Approval of matters reserved by condition

Development: Approval of details reserved by condition imposed under ref FP/52/21/PL relating to Condition Nos 3 - bin storage, 7 - electric vehicle charging and 8 - covered & secure cycle parking.

Location: 107 Felpham Way Felpham PO22 8QB

Bellus Quad Wheelie Bin Storage Unit – 4 x 240 Litre

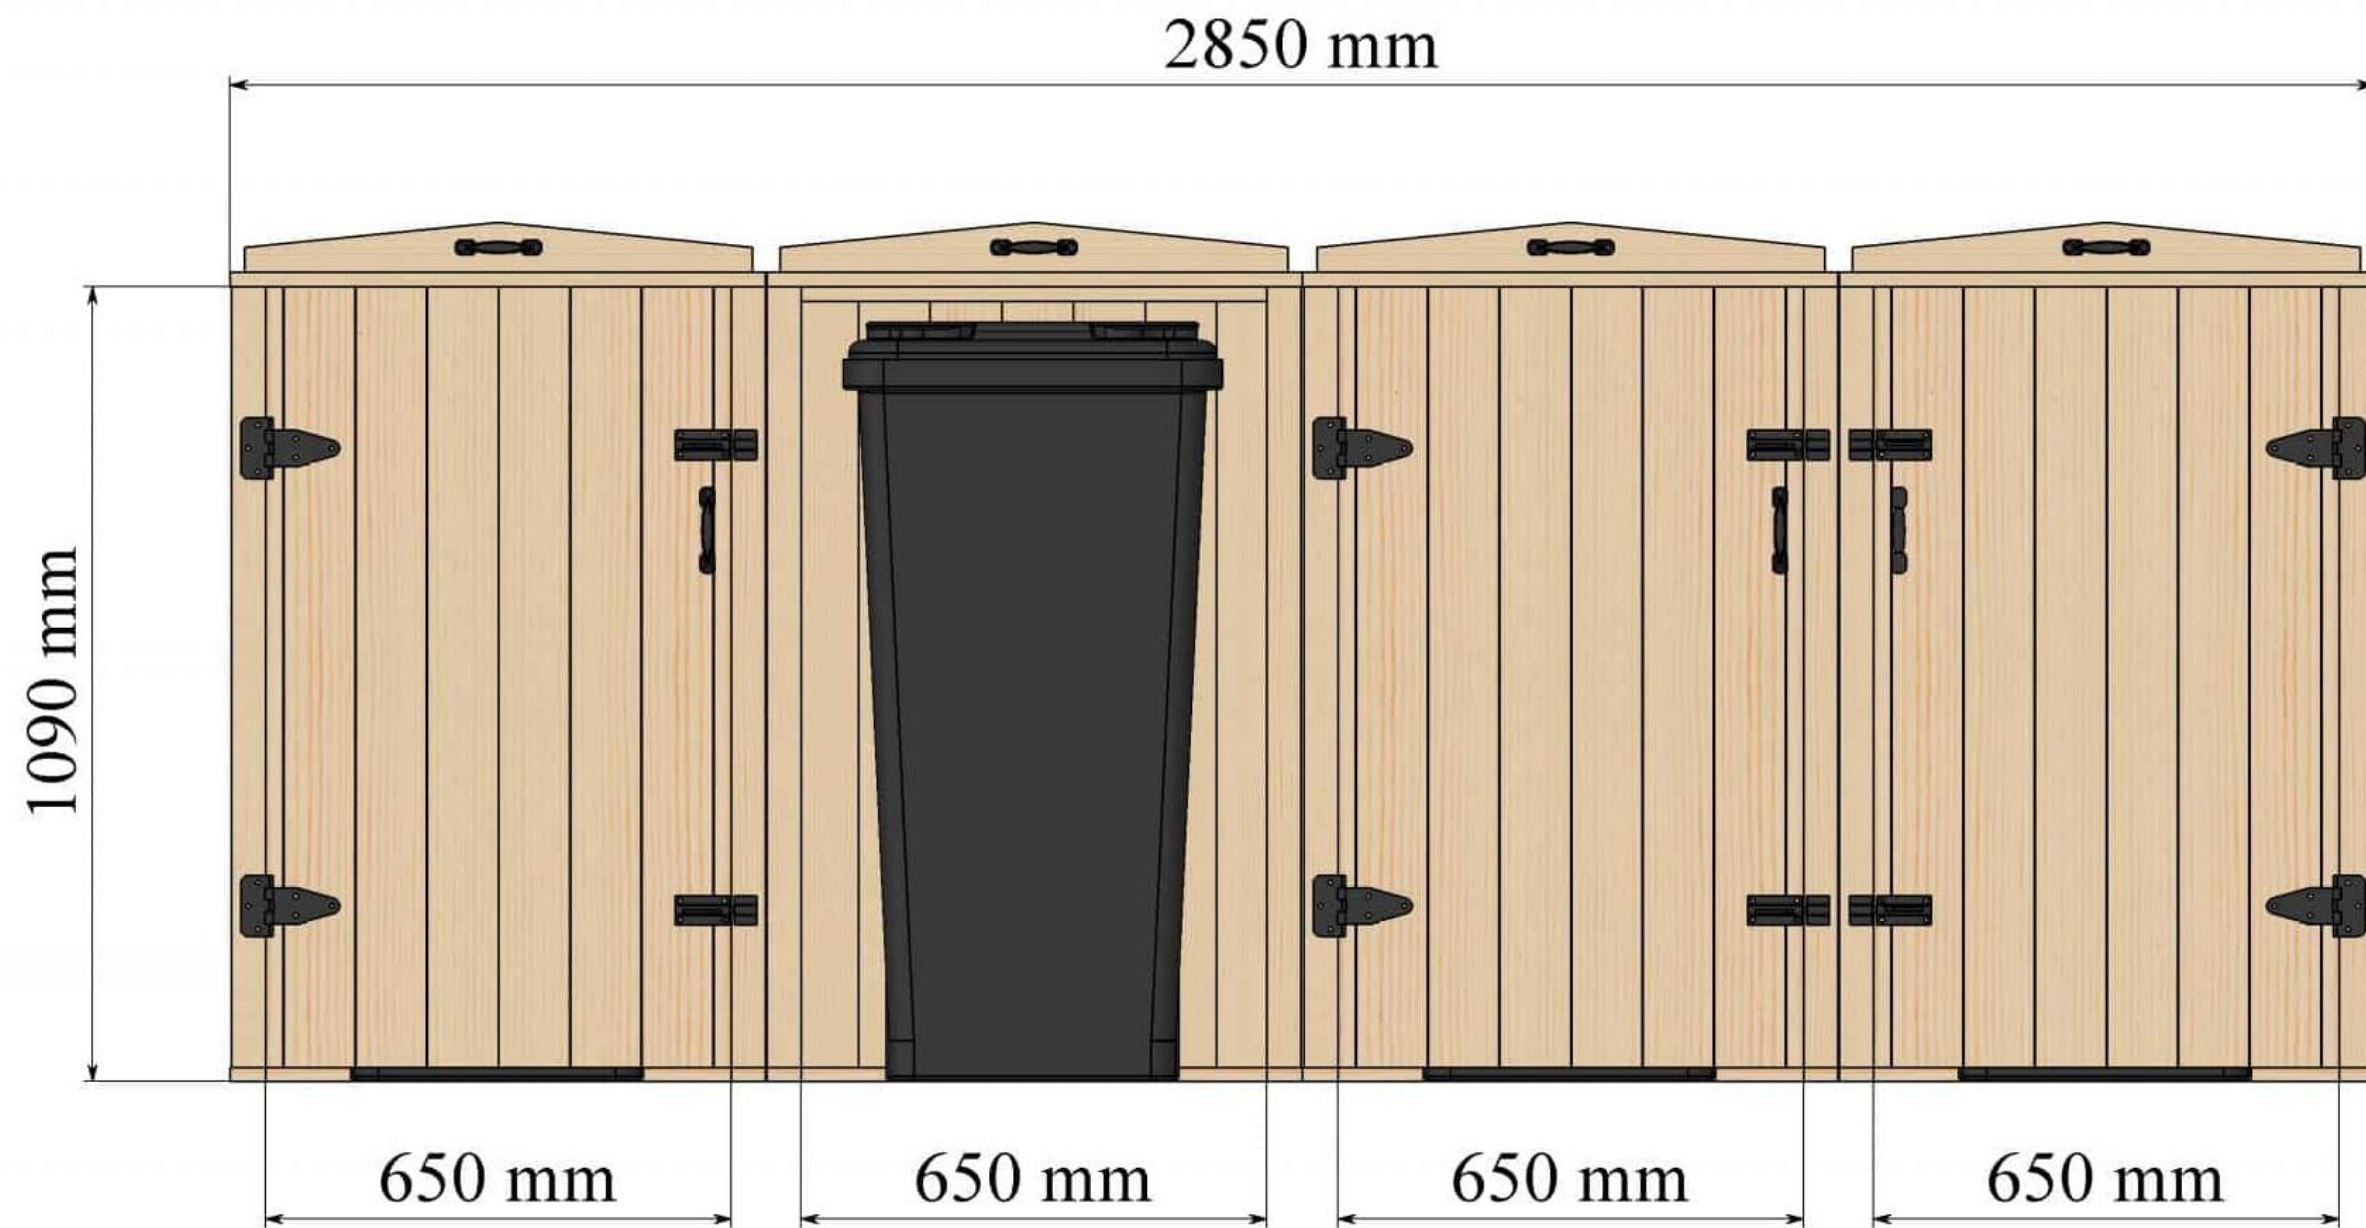
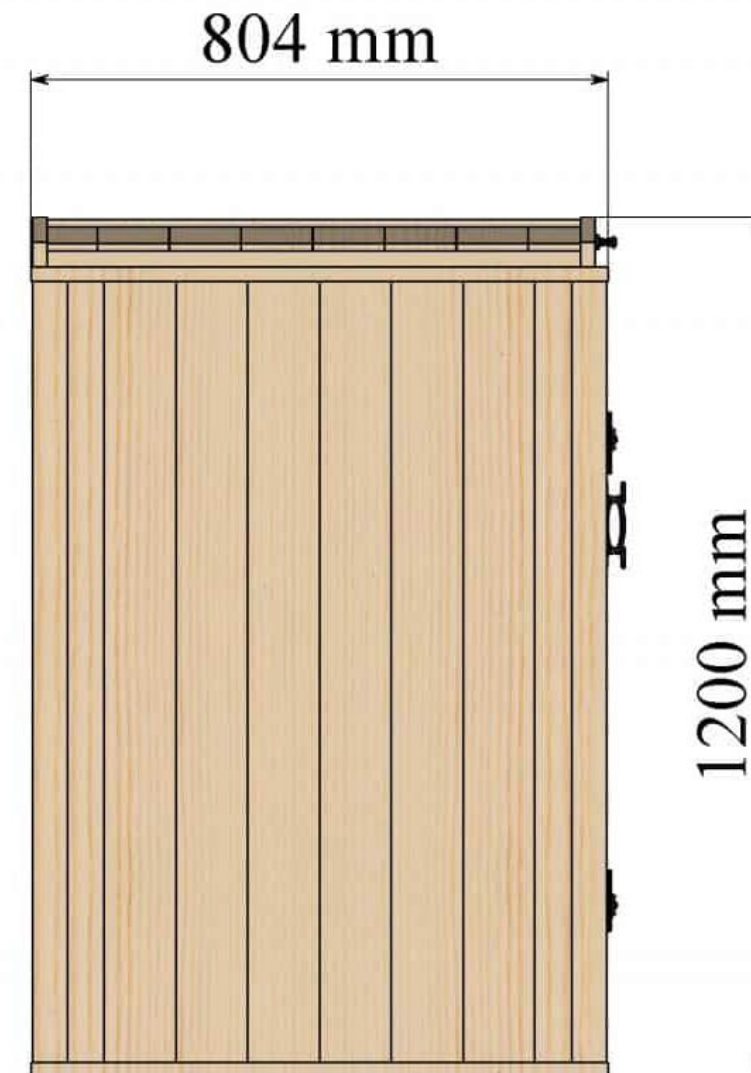
We are unable to scale plans at 1:10. As dimensions are included, please remove scale and re submit.
